**SSD 6010 - One Residential Building (Student Accommodation) within  
Darling Drive Plot**

**Submission by:**

**Mrs Anita Smythe**

**21 July 2013**

SHADOW DIAGRAMS: PLAN SHOWING THE HAYMARKET, WINTER SOLSTICE

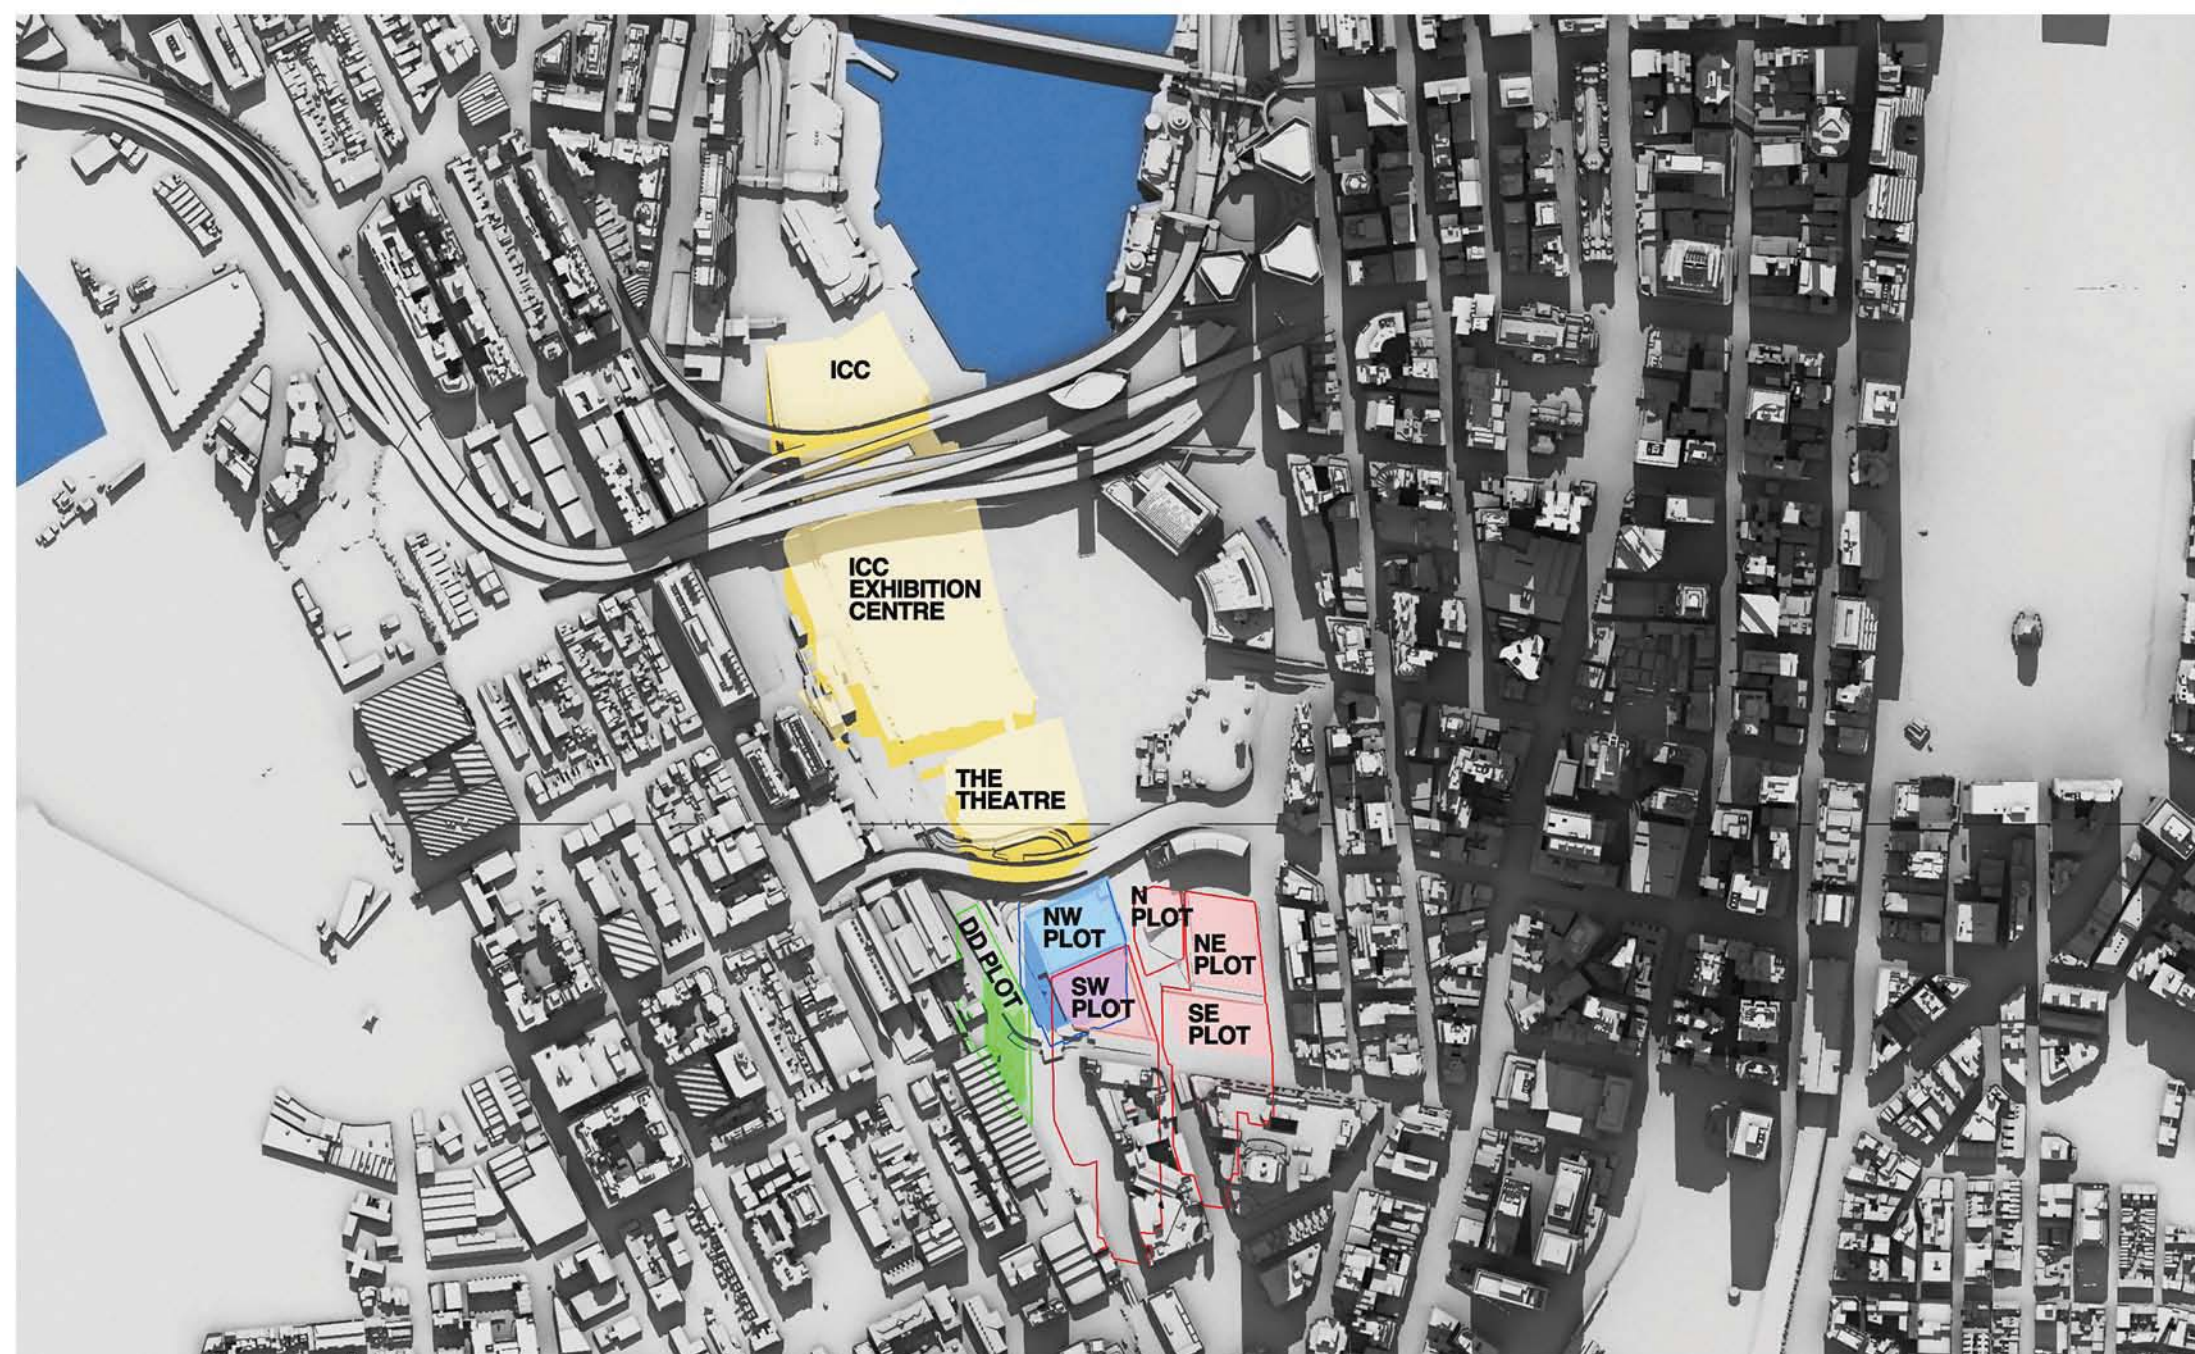
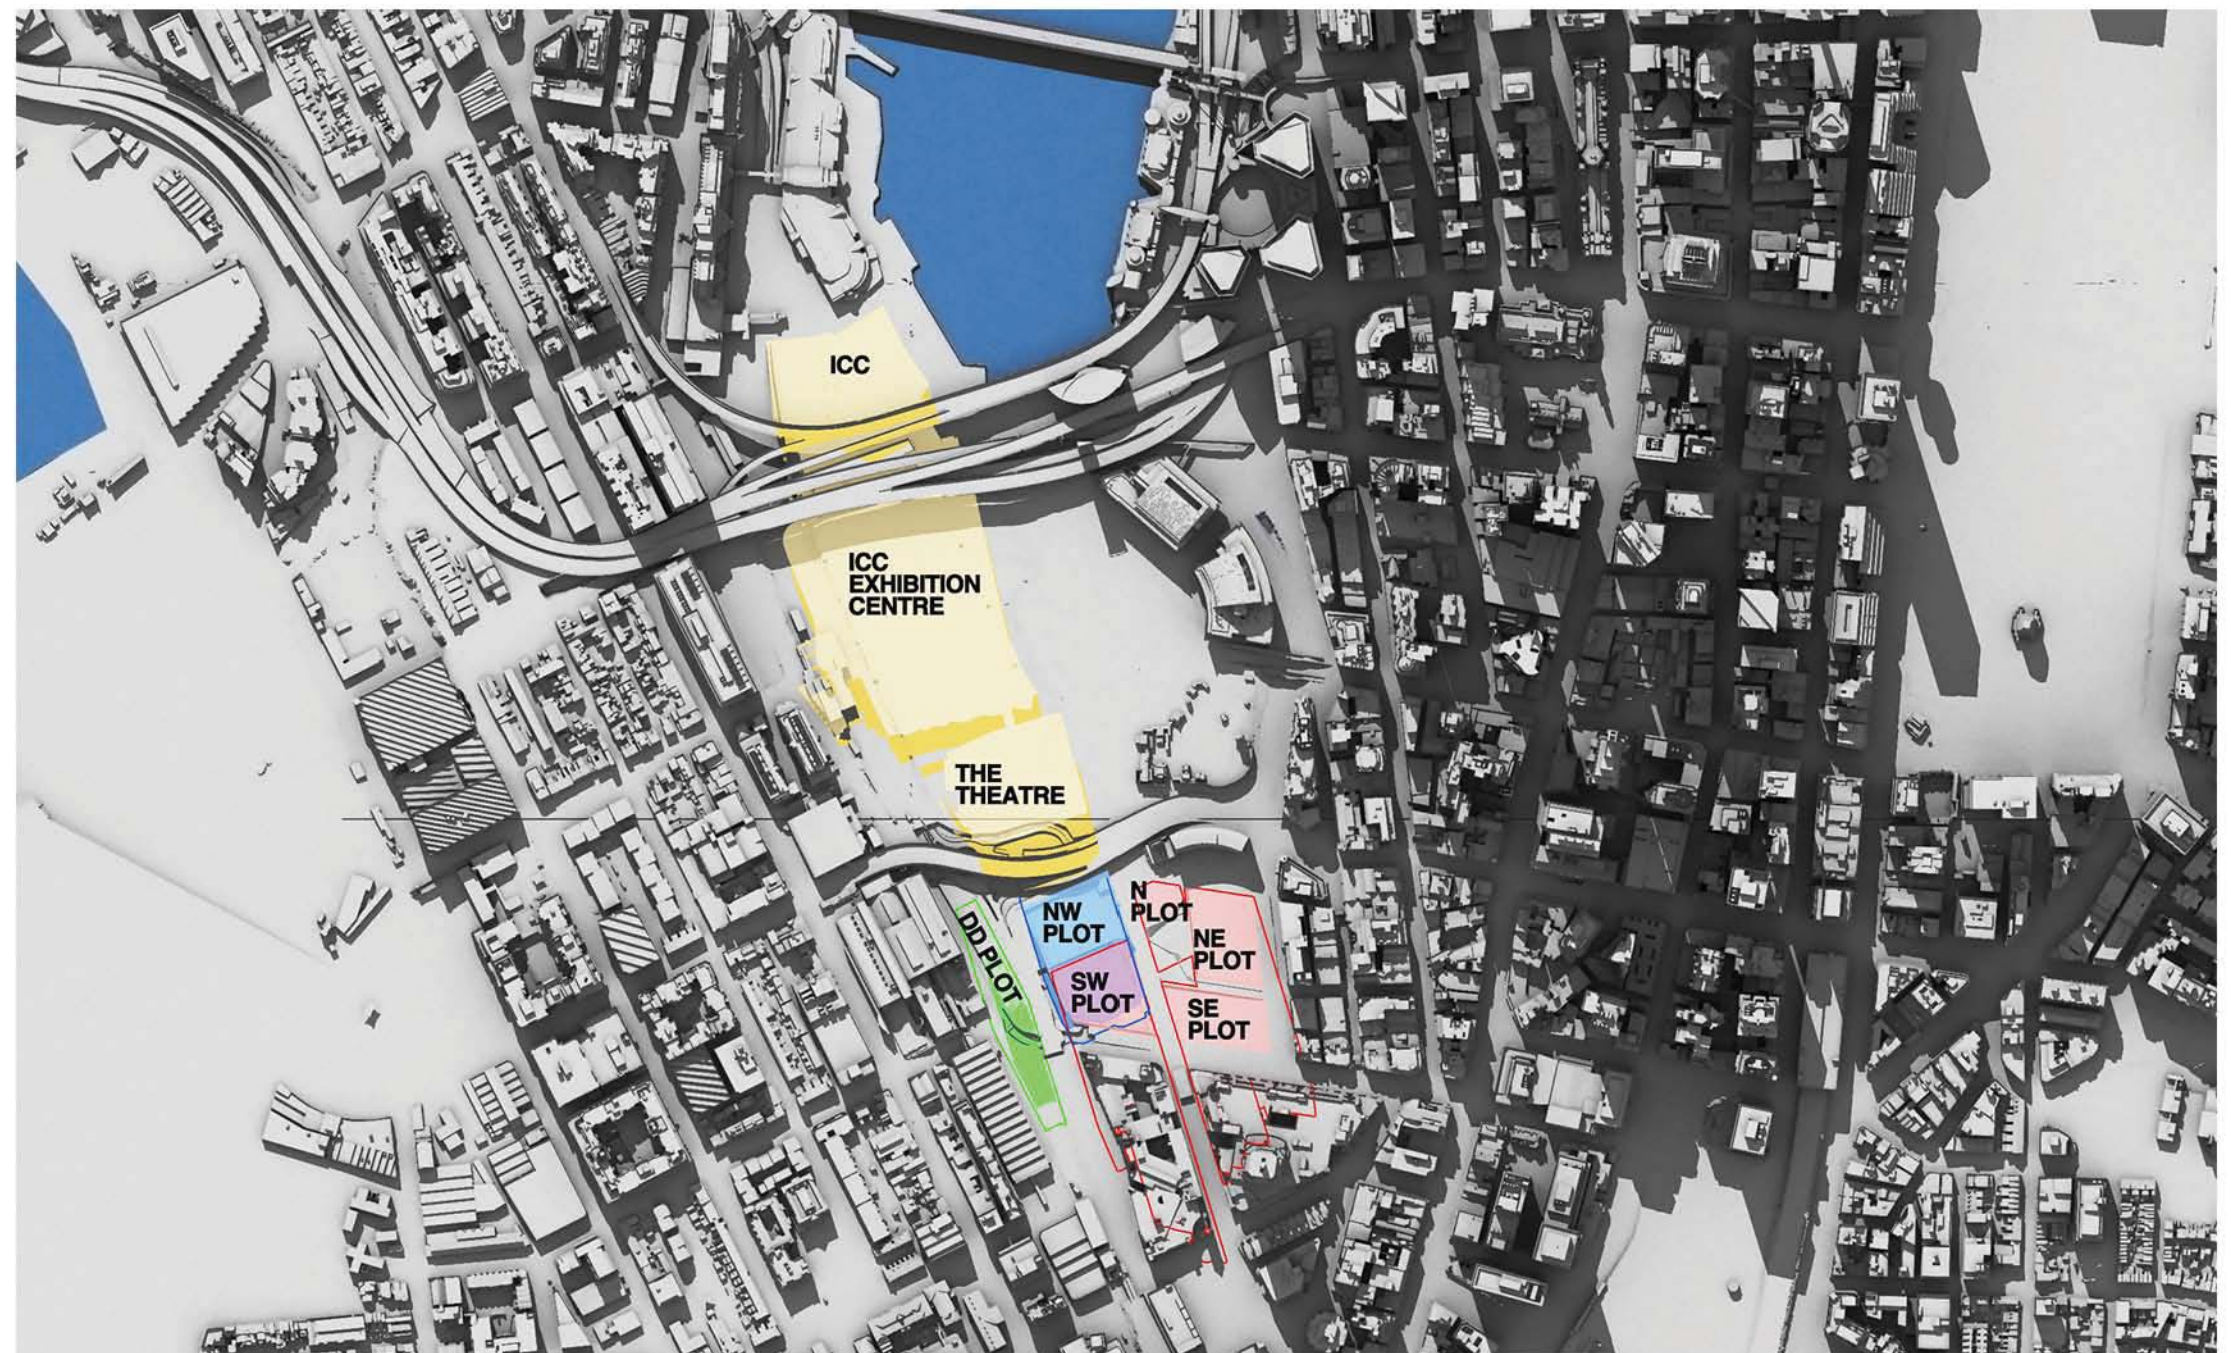
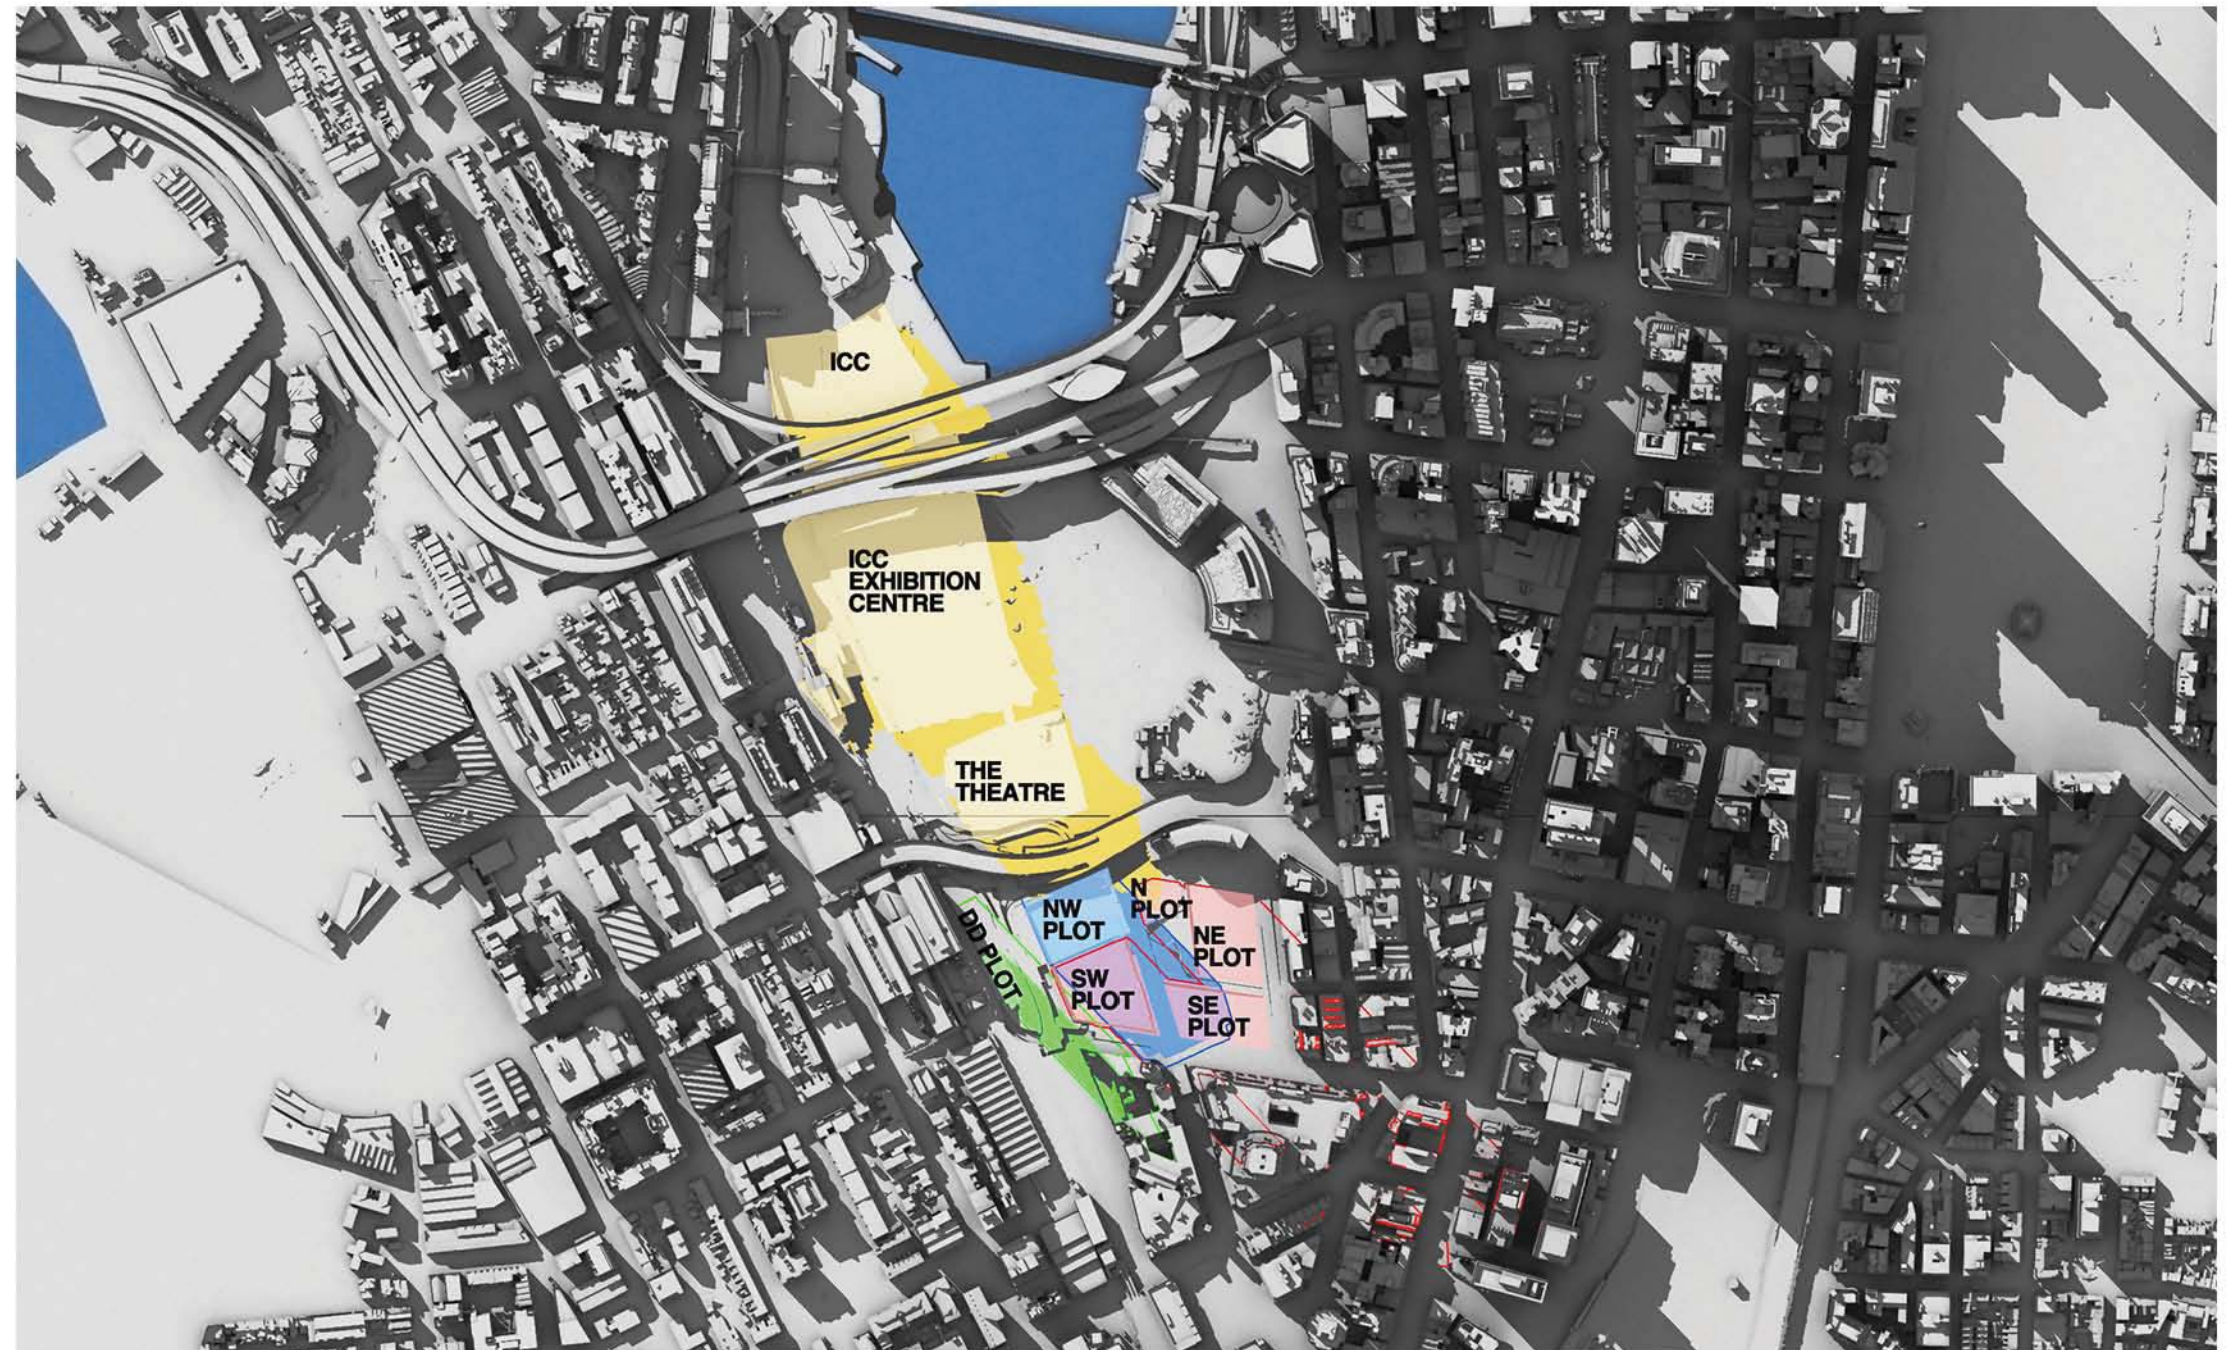
At 9am, 10am and 11am the west façade is totally in shadow due to other parts of The Peak building itself.

At 12pm there is still substantial existing shadowing on the west façade caused by the irregular shape of the west facade.

At 1pm the existing shadowing has been substantially removed, but not totally removed.

It can be concluded that some single aspect apartments on the west façade and some south-west dual aspect corner apartments currently receive less than 2 hours direct sunlight to habitable rooms and 50% of the private open space between 9am and 3pm on 21 June.

By 2pm the existing shadowing has been totally removed, but that is too late to achieve two hours of direct sunlight before 3pm.

At 9am, 10am and 11am the west façade is totally in shadow due to other parts of The Peak building itself.

At 12pm there is still substantial existing shadowing on the west façade caused by the irregular shape of the west facade.

At 1pm the existing shadowing has been substantially, although not entirely, removed. However, overshadowing of lower levels of the west façade by the concept proposal parameter plan shadows for the N,NE and SE plots has already started.

By 2pm the existing shadowing has been totally removed. However, overshadowing of the west façade by the SSDA4 and SSDA5 buildings has appeared and risen further up the west façade than the concept proposal parameter plan shadows for the N,NE and SE plots, which is still present.

At 3pm, the proponent states correctly that 45-45% of the western façade is overshadowed by the SSDA4 and SSDA5 buildings.

It can be concluded that, as a result of combination of the proposed development with existing shadowing of the west façade, some single aspect apartments on the west façade and the south-west dual aspect corner apartments which currently receive less than 2 hours direct sunlight to habitable rooms and 50% of the private open space between 9am and 3pm on 21 June will suffer additional overshadowing. It is beyond our skills to count the number of such apartments. We note that the proponent has made no attempt to do so.

Rather than counting the number of units which will not meet the DCP guidelines, the proponent attempts to trade-off direct sunlight at 4pm for lack of direct sunlight during the period 9am to 3pm. There is no provision in the DCP guidelines for such a trade-off.
